Hi Emma,

I refer to the points identified below in the email from AP&S and provide the following comments:

Road Reserve Width

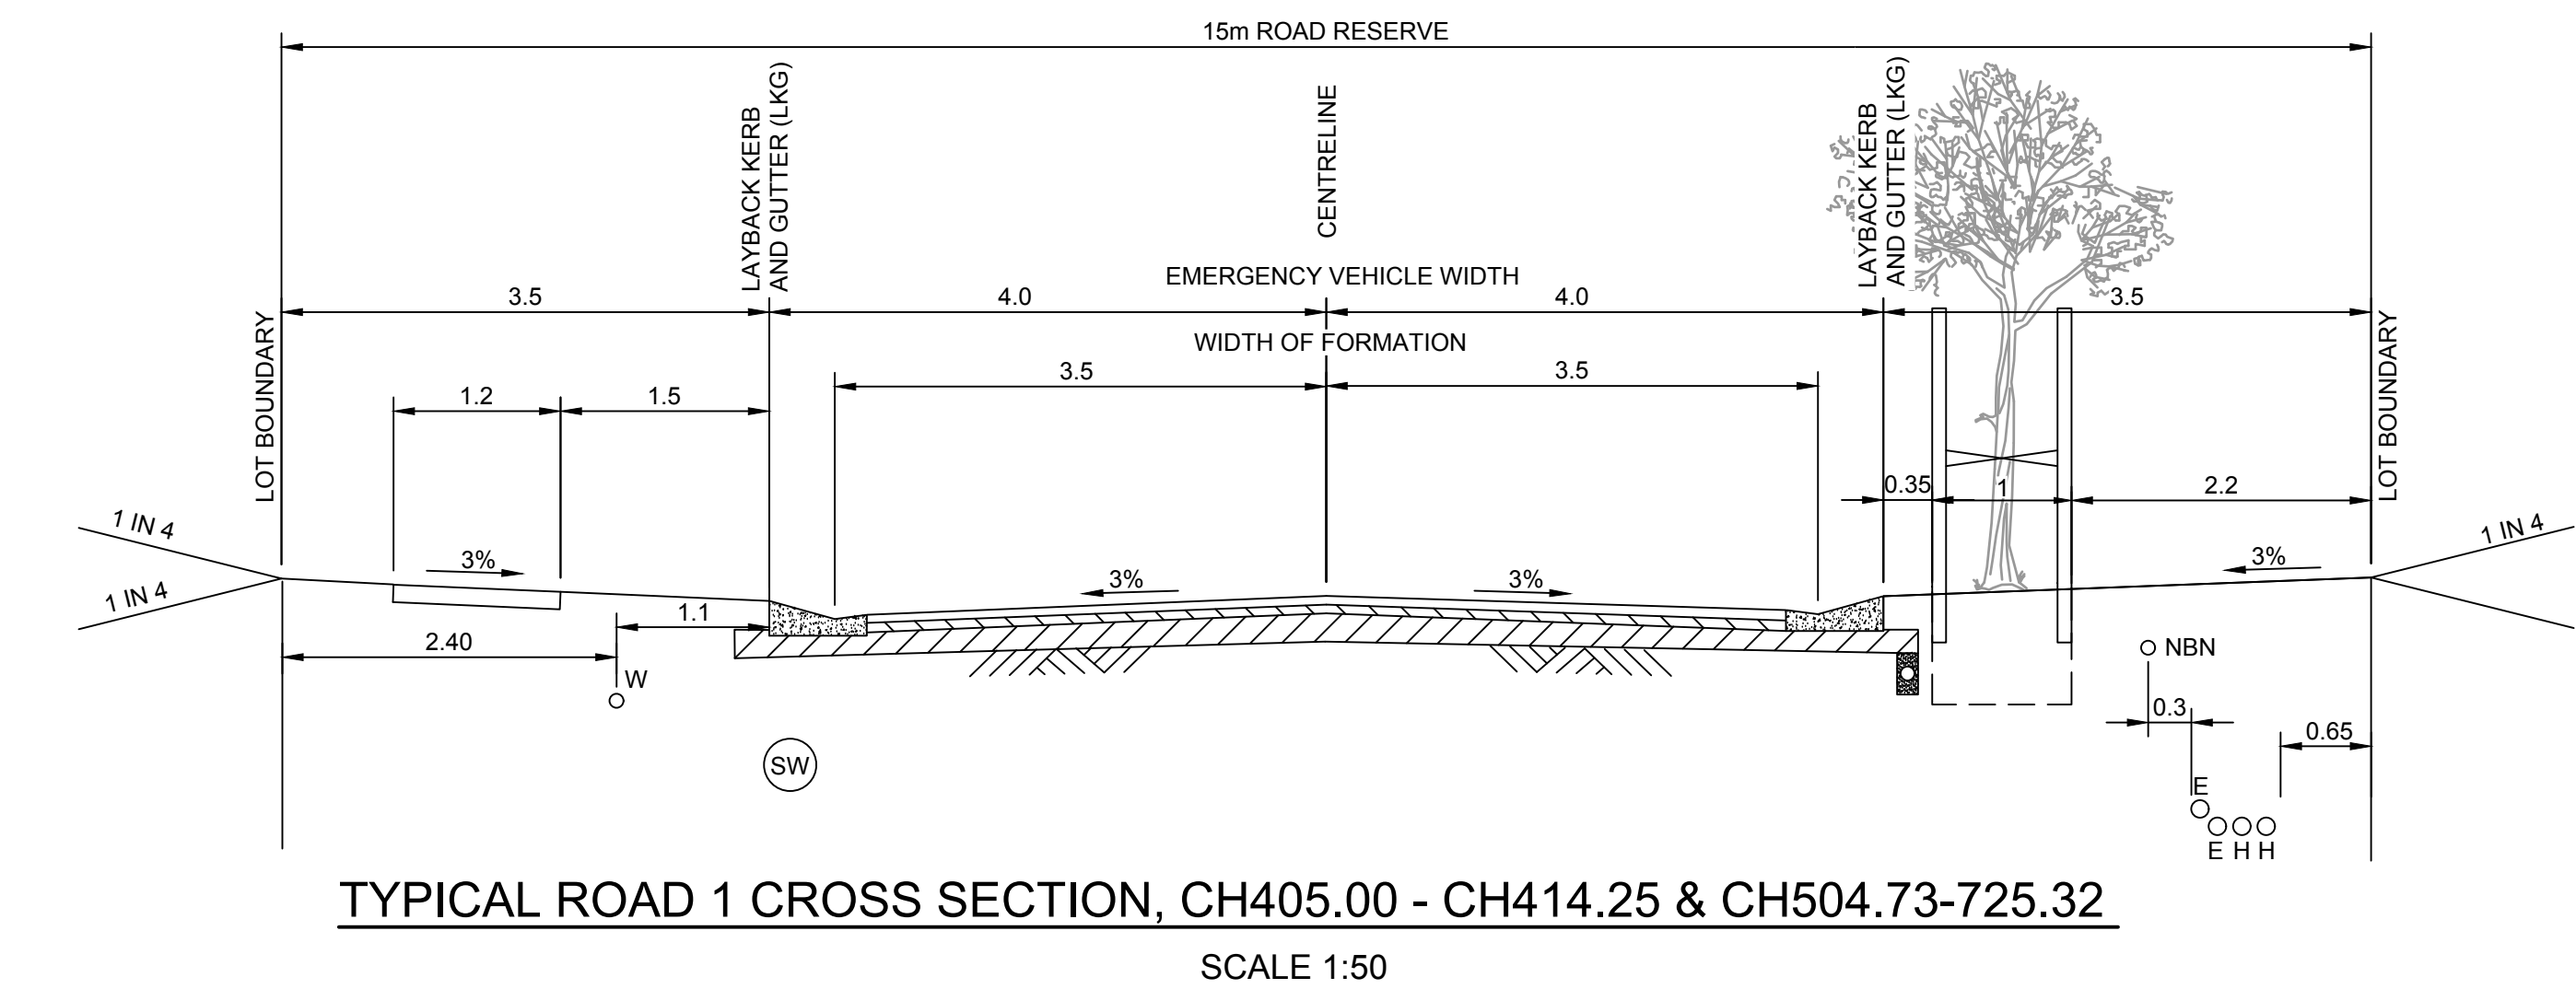
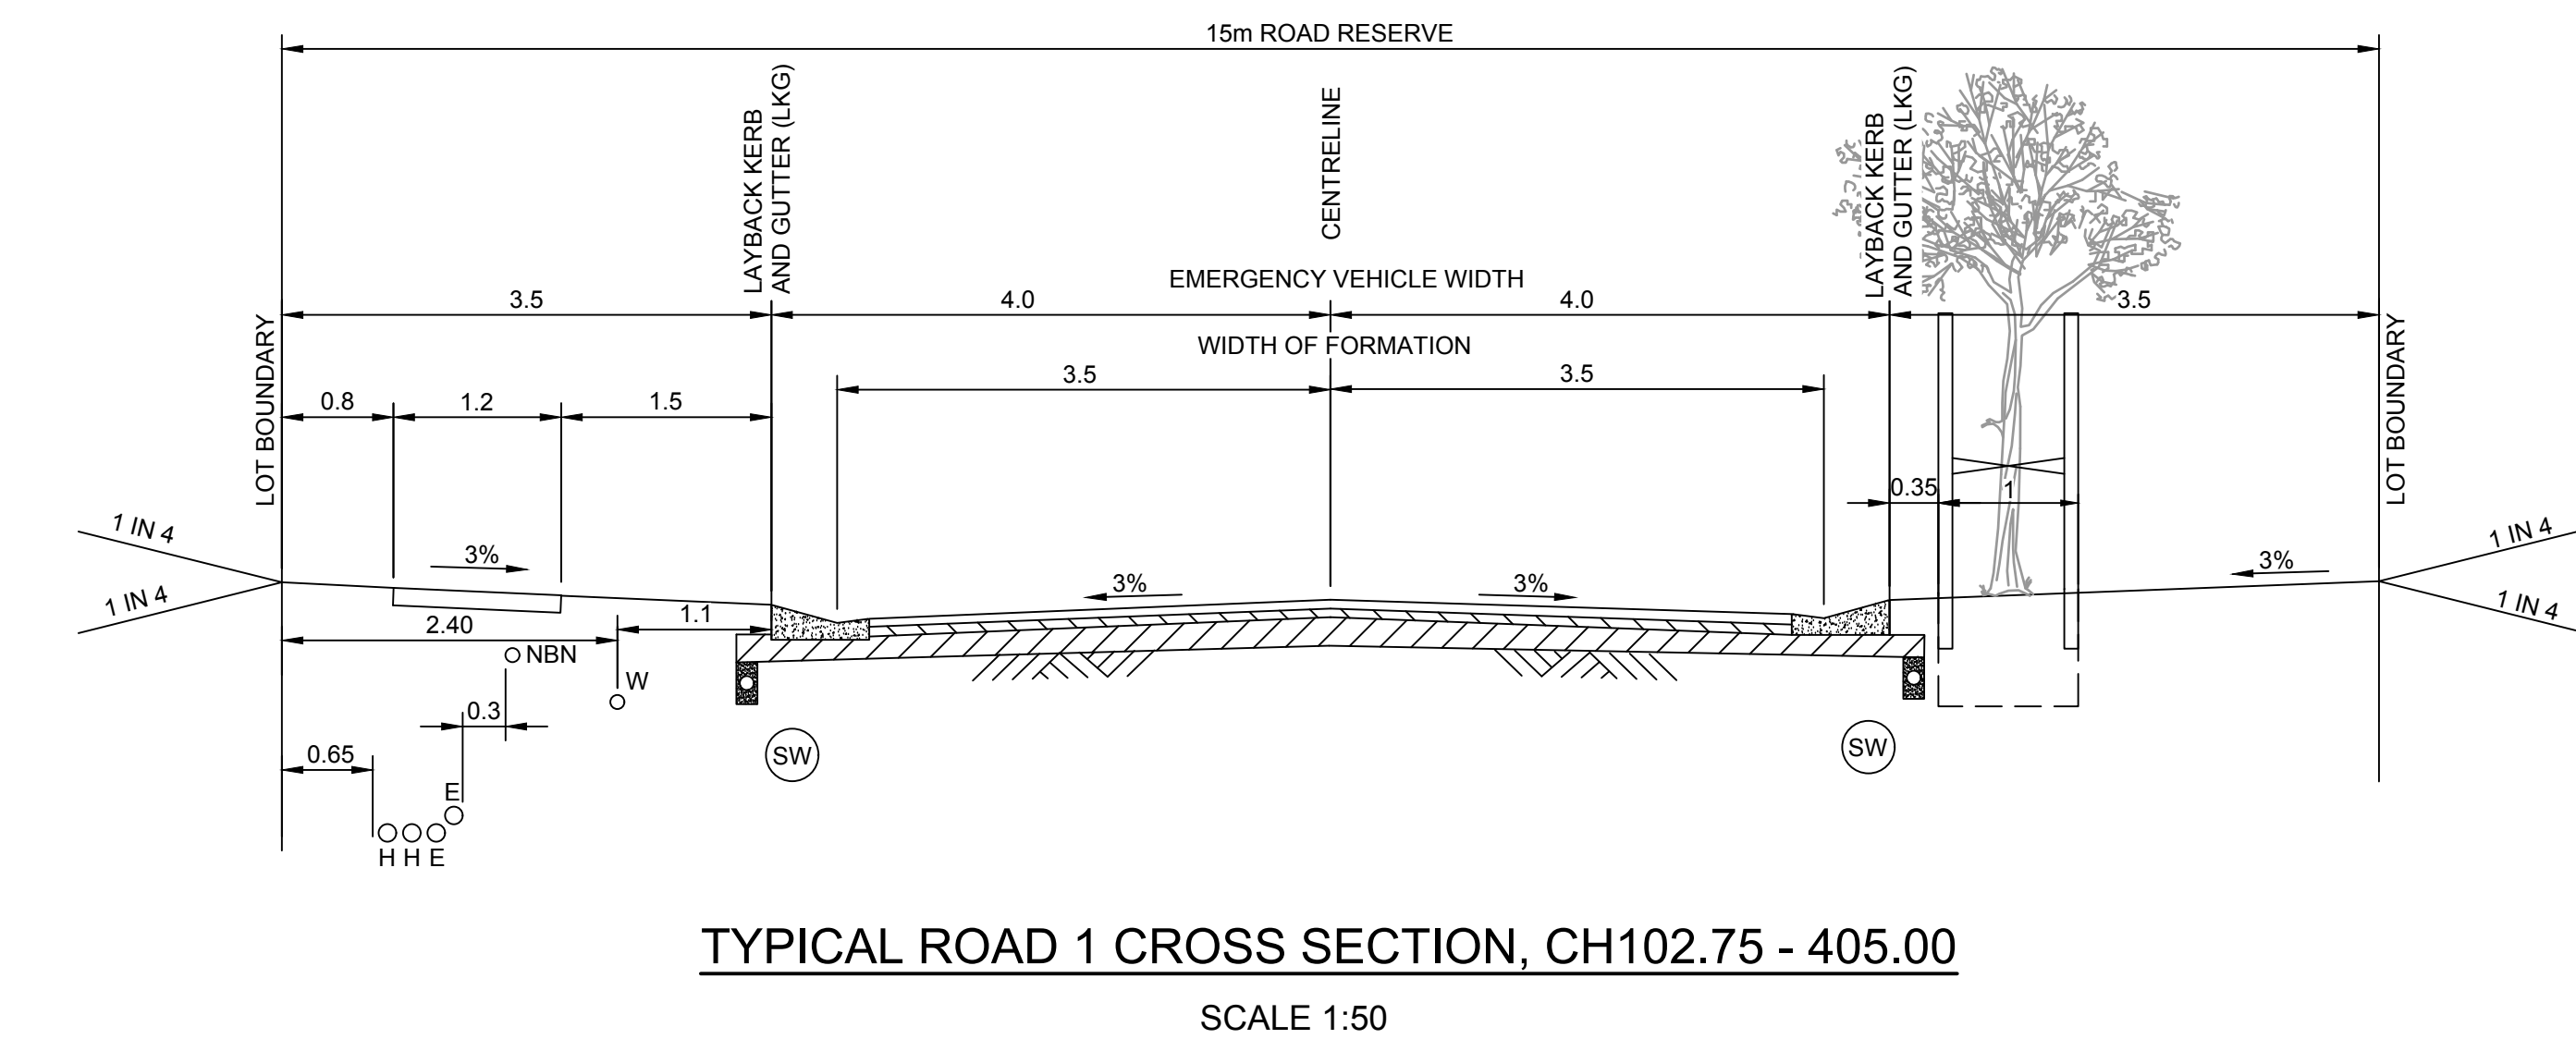
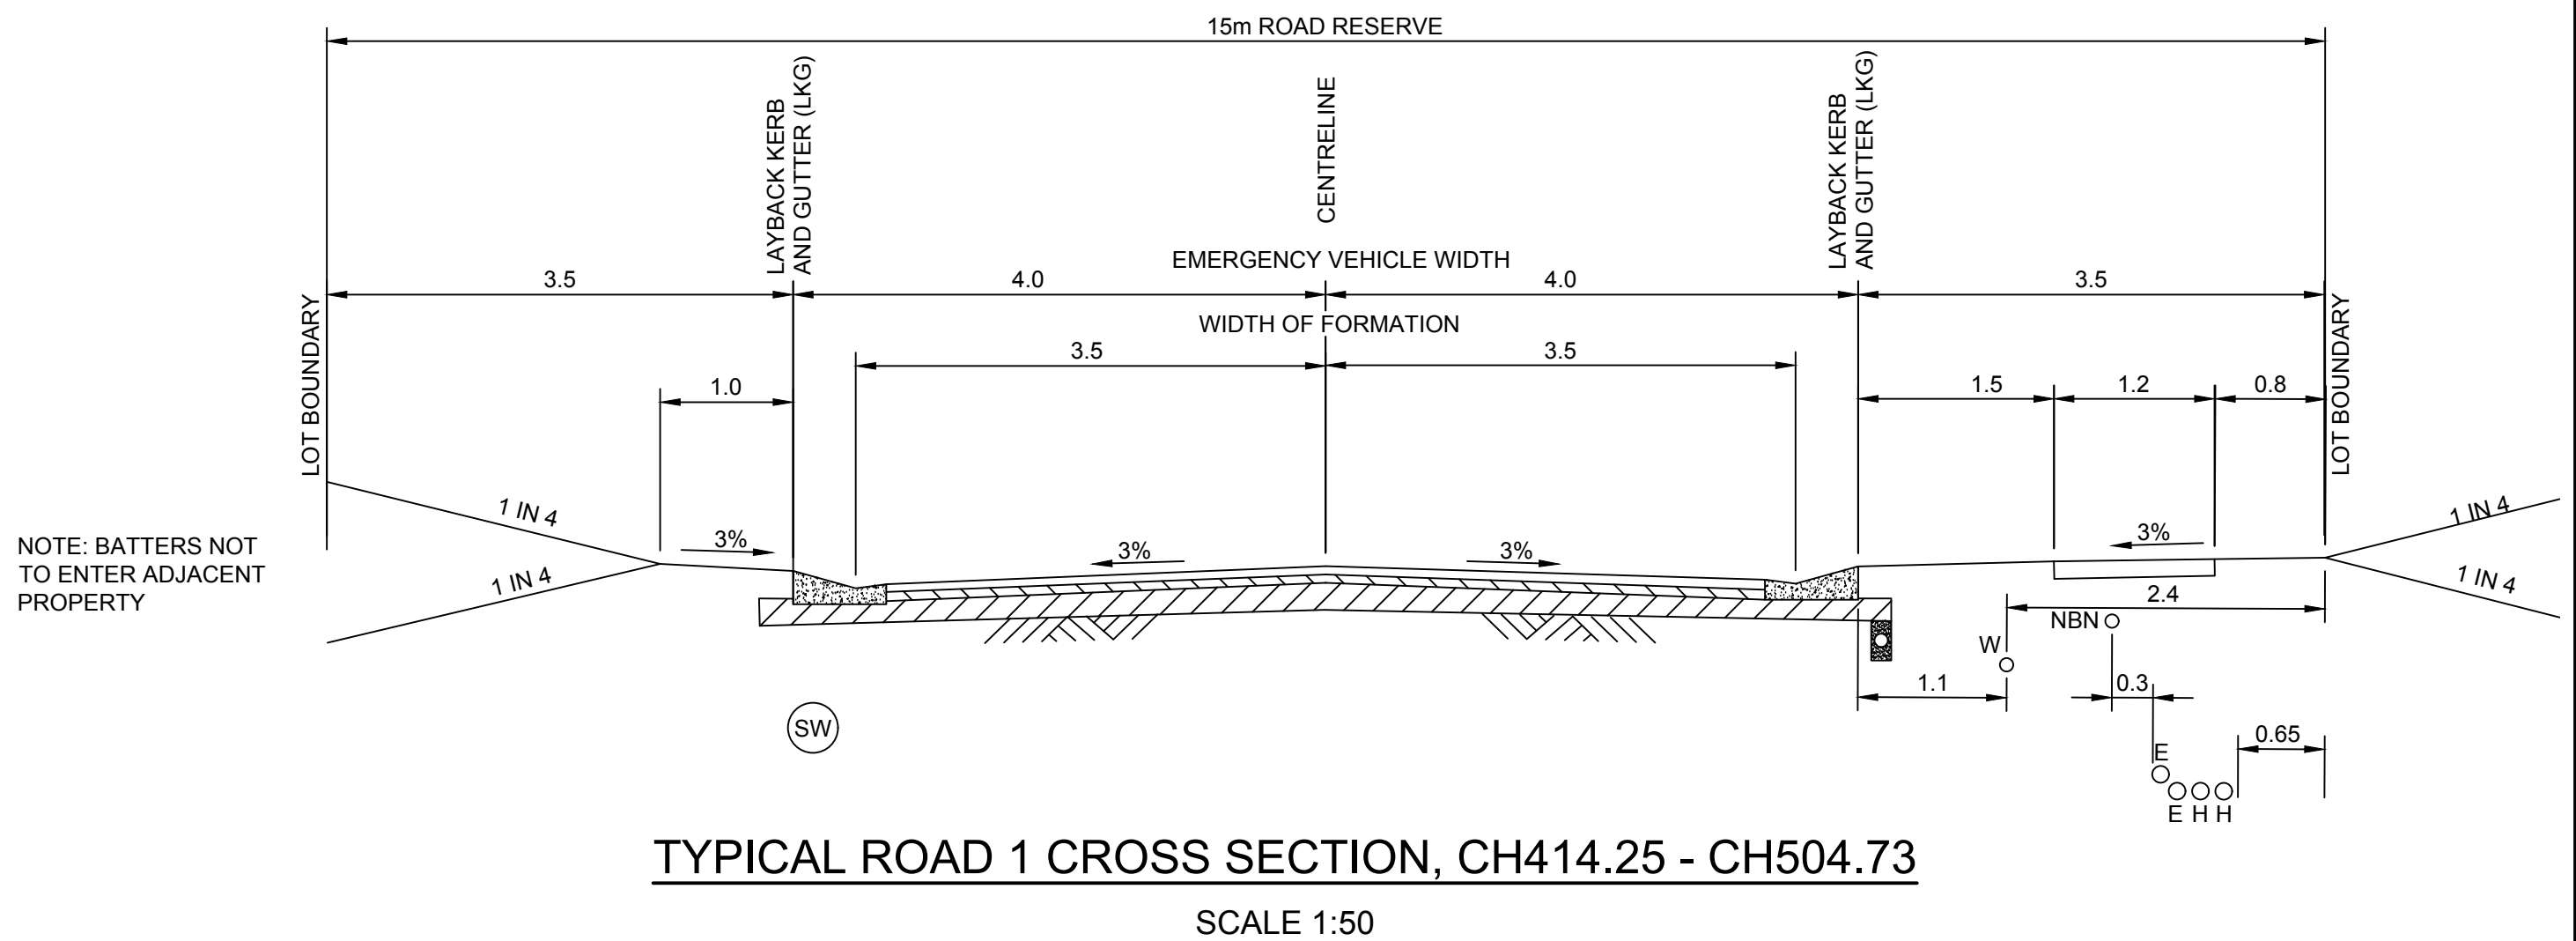
Council recognises the constraints of the layout and recommends the following road requirements.

- Road 1 (Entrance Road) CH0.00 to CH135.00,
 - 15m Road Reserve width as restricted by existing property boundary.
 - 7m wide carriageway (kerb invert to invert);
 - Upright Kerb – No property driveway required on this section of road
 - 2m width shared path on northern side

- Road 1 (Loop Road) CH135.00 - CH414.25 & CH135.00 - END
 - 16m Road Reserve width as per SDCP2014 Chapter G11.
 - 7m wide carriageway (kerb invert to invert);
 - Layback Kerb – for dwelling driveway;

- Road 1 (Section A) adjoining public reserve
 - **16m** Road Reserve width as per SDCP2014 Chapter G11.
 - **7m** wide carriageway (kerb invert to invert);
 - **Upright Kerb** – No property driveway required on this section of road;
 - **Open swale drain to** connect overland flow from drainage easement along the eastern side boundary of Lot 23 to drainage easement along eastern boundary of Lot 63,
 - **Multi-purpose:**
 1. for stormwater drainage management (to minimise overland run-off on road from northern drainage easement to Road 1 then discharge back to southern easement) and
 2. restrict future driveway access to existing dwellings on eastern side of subdivision

- Condition C9. 1) c. The entrance road shall have a 15m road reserve width with a 7m wide carriageway (kerb invert to invert) with upright kerb. The loop road shall have a 16m road reserve width with a 7m wide carriageway (kerb invert to invert) with layback kerb. Upright kerb is to be used on the section of road adjoining the public reserve. *(the remainder of C9.1c) to continue as per draft)*
- New condition C12 d) An open swale drain is to be constructed within the 2m wide public reserve to connect the overland flow from the drainage easement along the eastern side boundary of Lot 23 to the drainage easement along the eastern boundary of Lot 63
